Summary of Amended Application

Langton Grove 22 HA6 2PS

PP-14170697

2

PROPOSED REAR ELEVATION

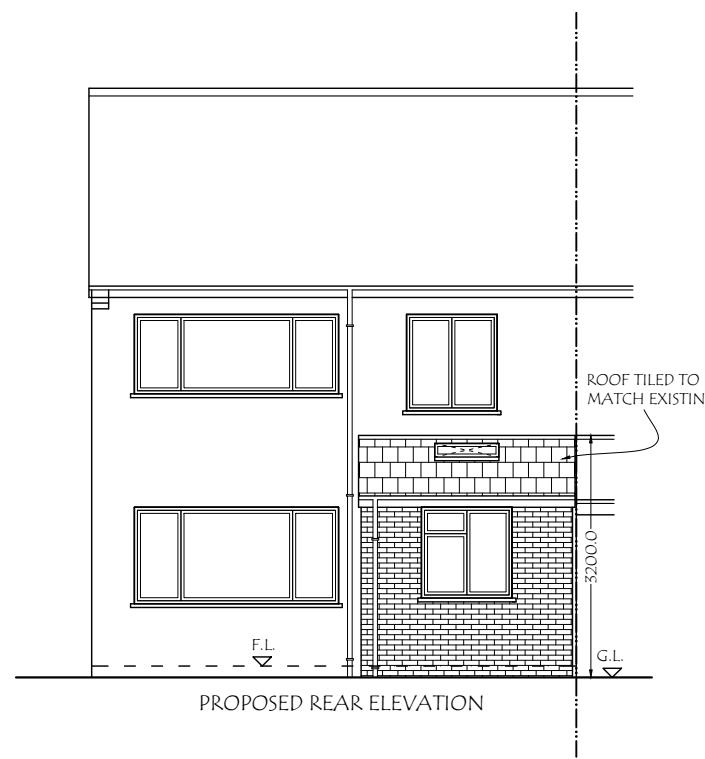
added a rear window to proposed extension in drawings
